APPLICATION NO: 20/01047/FUL/ADDINF

DESCRIPTION: Erection of single storey rear extension and garage conversion.

LOCATION: 25 Swan Lane Sandhurst Berkshire

Drawing Title  
Site Location and Block Plan

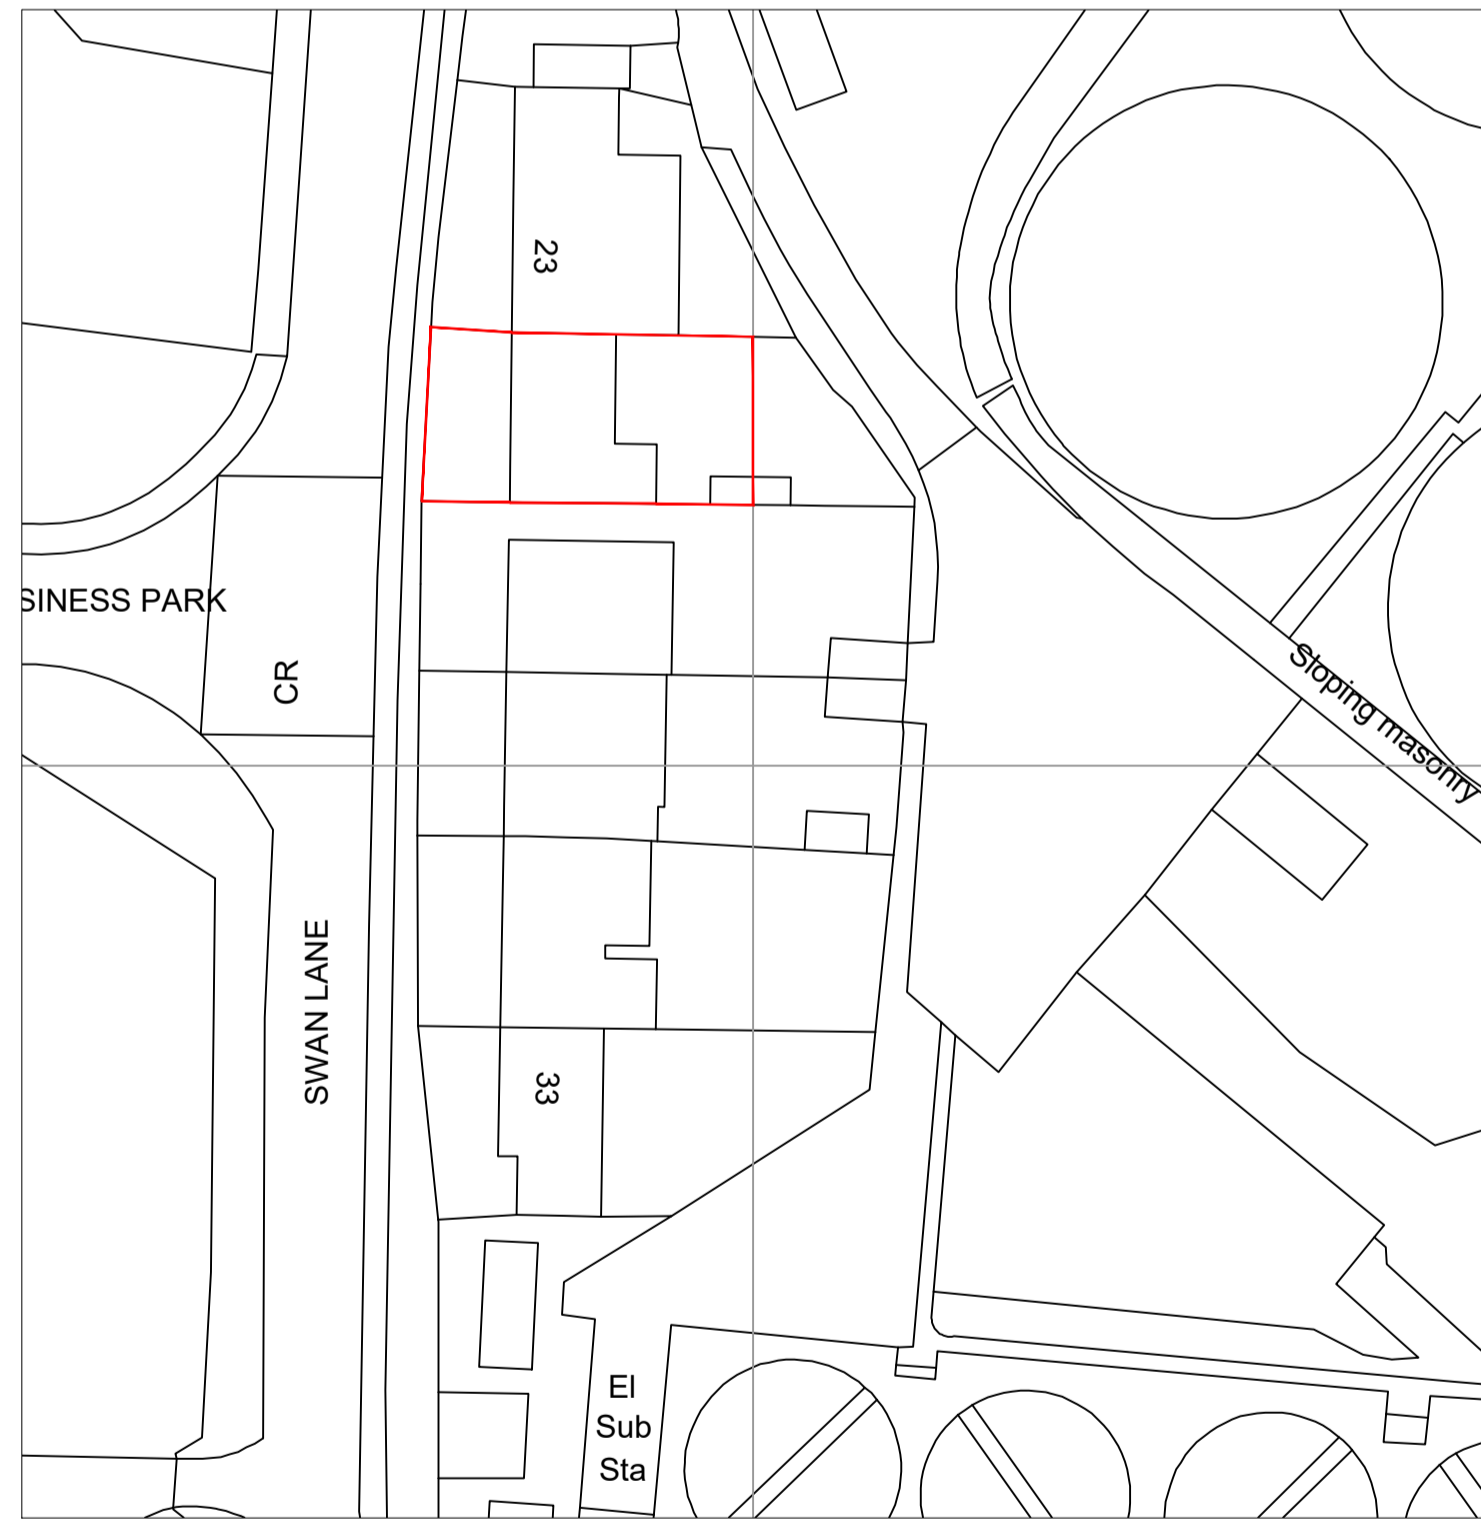
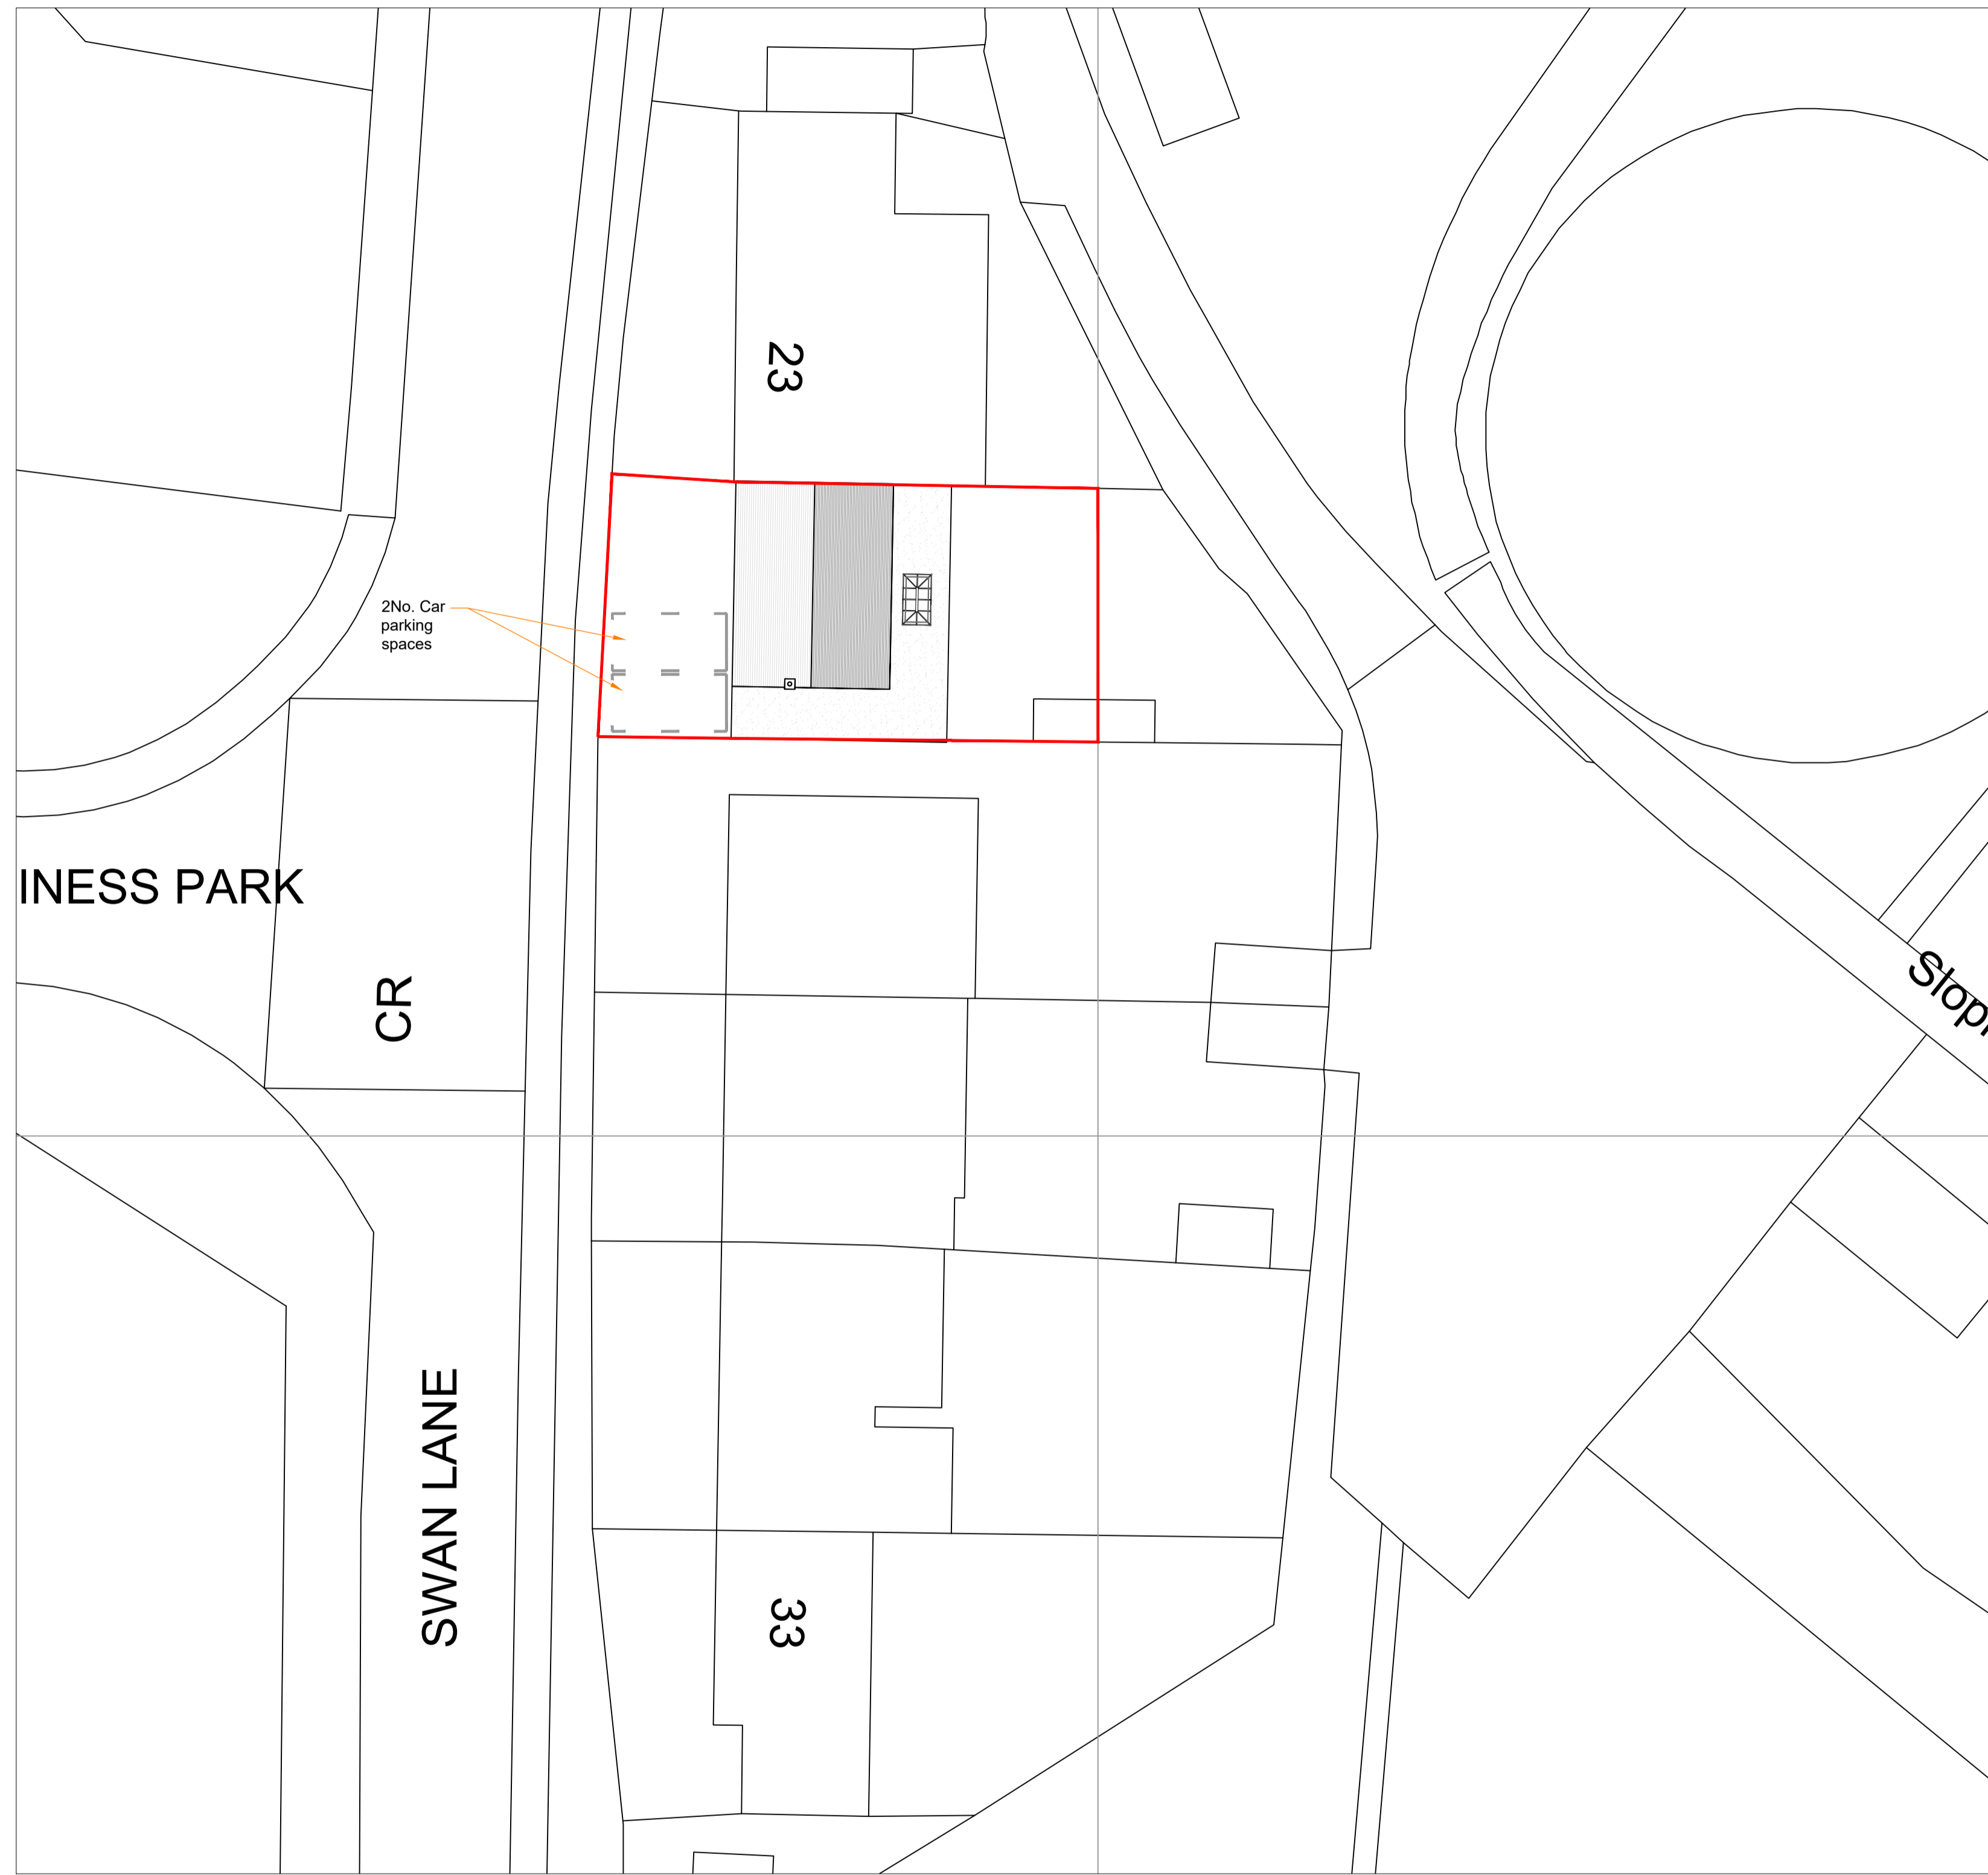
- 1 The proposed elevations have incorrectly been labelled as existing, please could this be amended.
- 2 Please provide a parking plan.
- 3 Please confirm whether there will be any encroachment (including roof overhang/guttering etc.)
